Case Officer: Catherine Harker **Recommendation:** Approve

Applicant: Sir Stephen Gomersall

Proposal: To move existing window on rear elevation by 50-60 centimetres
(following permission granted in decision of 9 October on application
20/02076/LB)

Drawing No: **6601-07b** Date: **14/5/2019** Scale: **As indicated@A1**

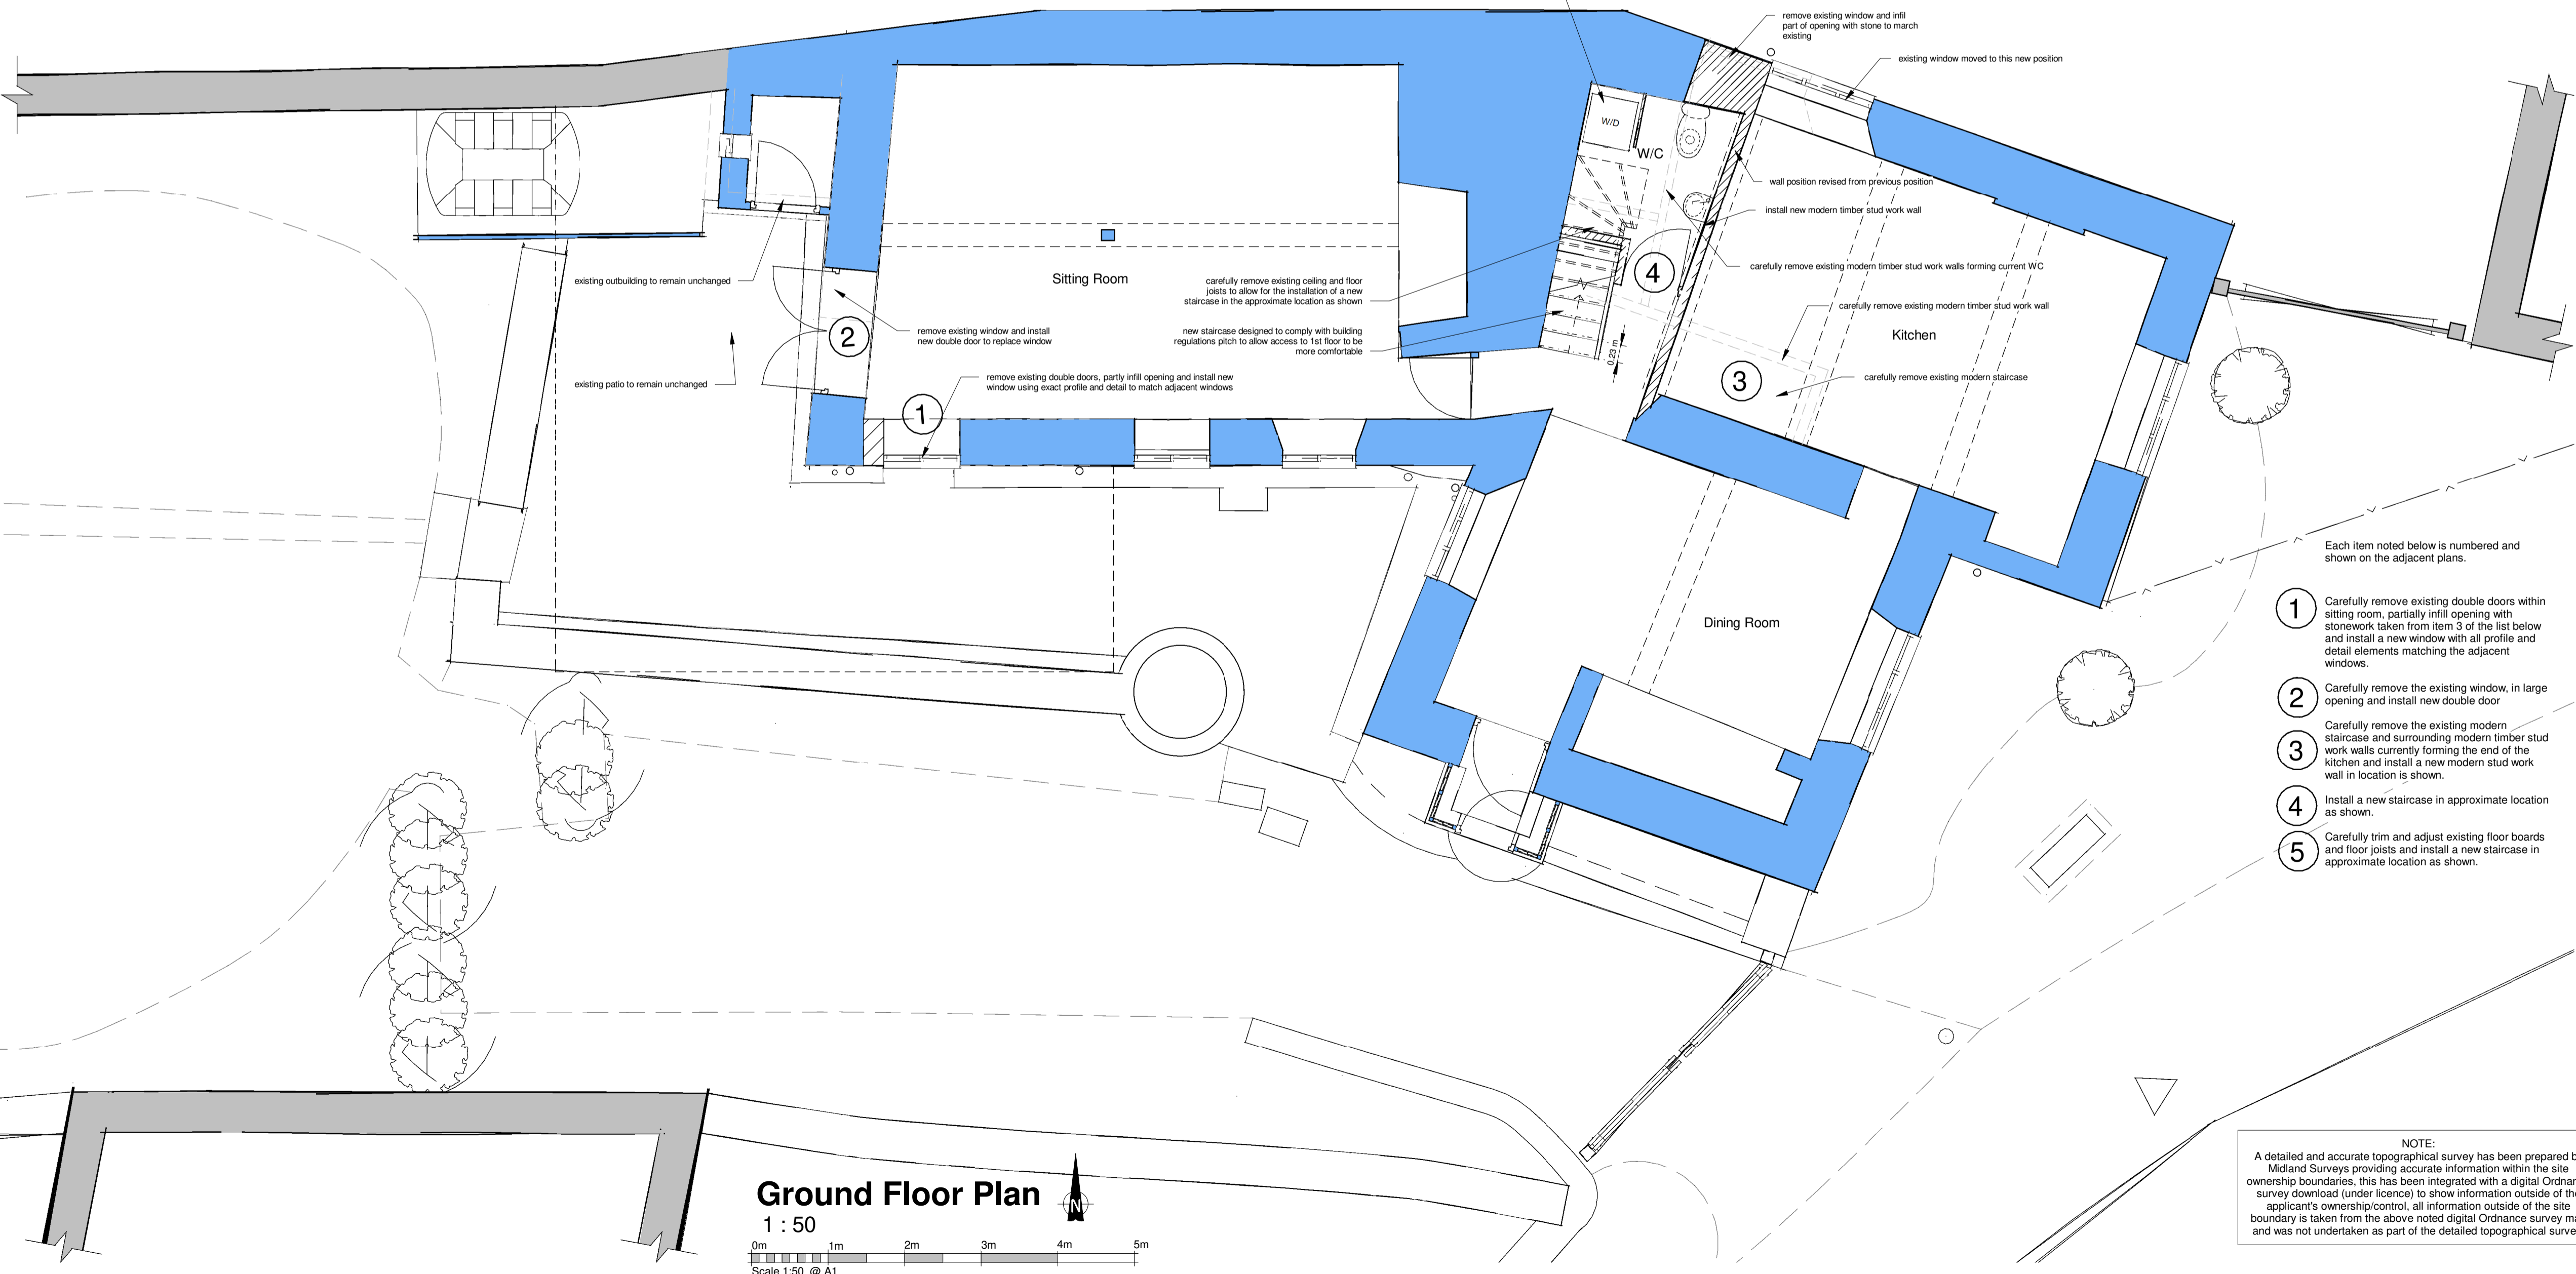
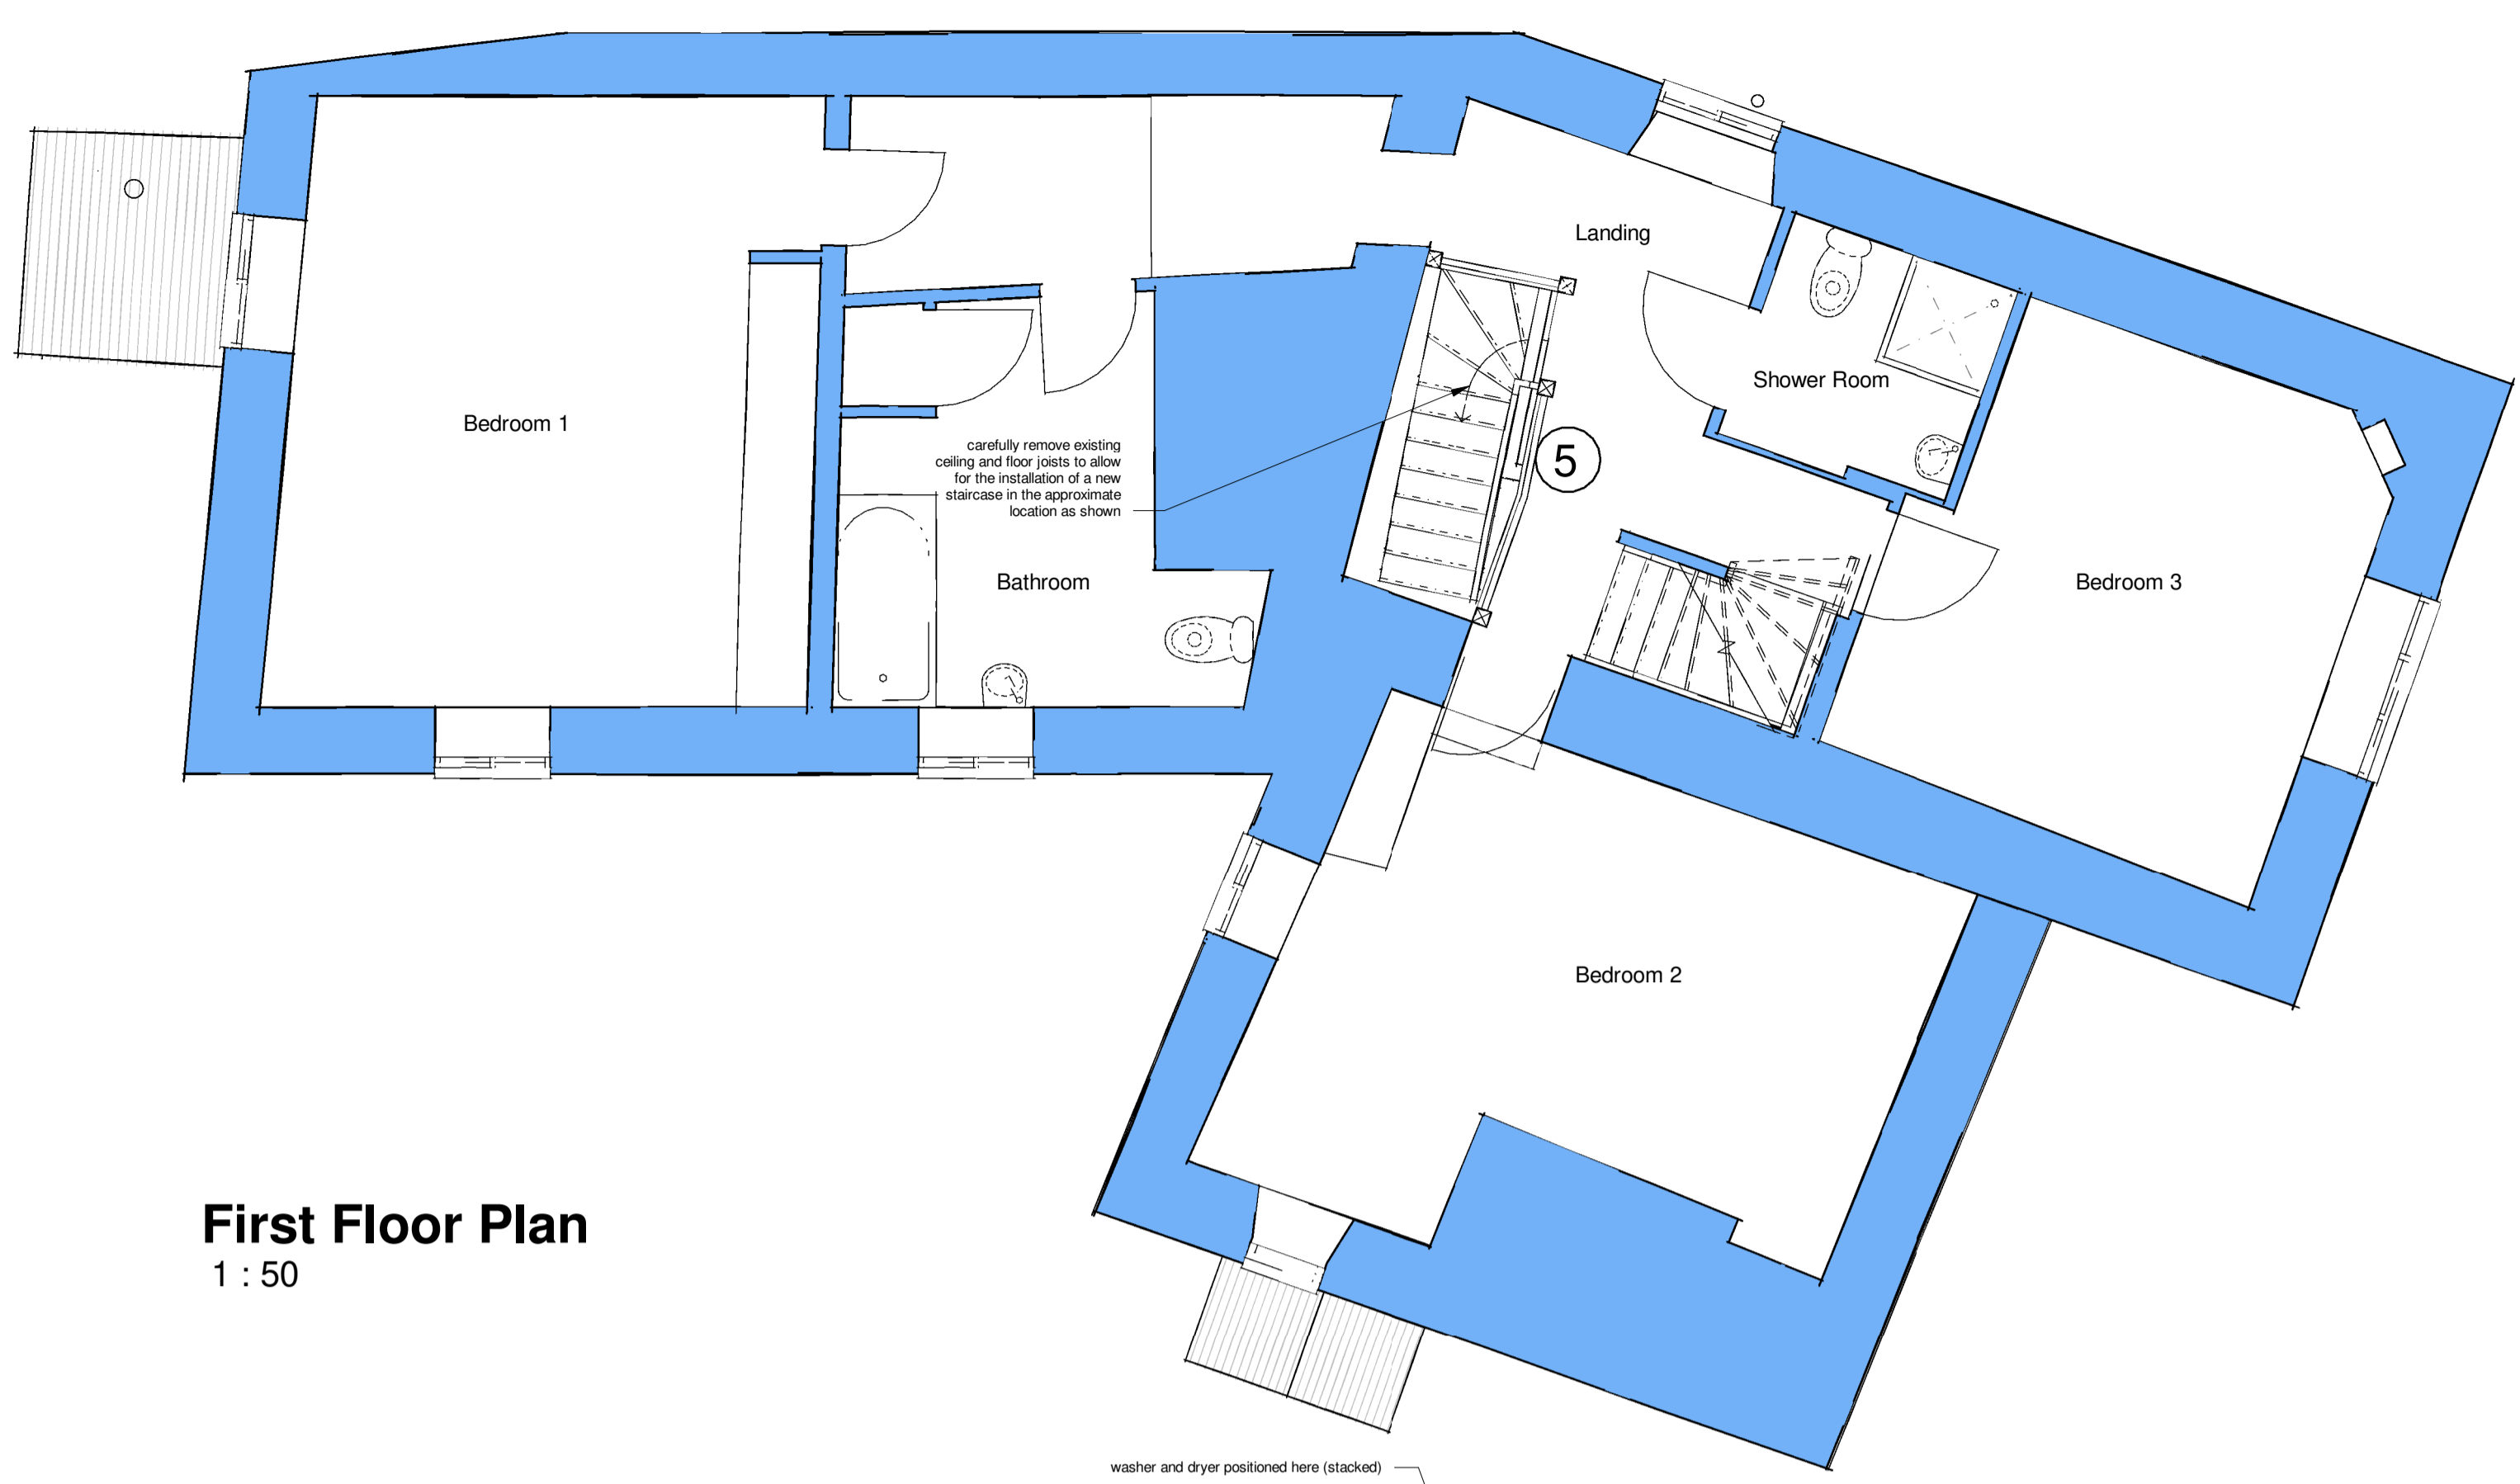
- 6.5. It would be preferable for the window to remain in its current location and be subdivided (given that the window itself is not of historic merit), but the applicant's proposals have changed.

- 6.6. The current proposals lead to some disruption of the historic fabric and potentially some limited harm. However this harm is not considered to impact on the core significance of the building.

- 8.10. Although the Conservation Officer would have preferred the windows to remain its current location it is not considered that that any harm would be significant enough to require a refusal and a positive recommendation is therefore made.
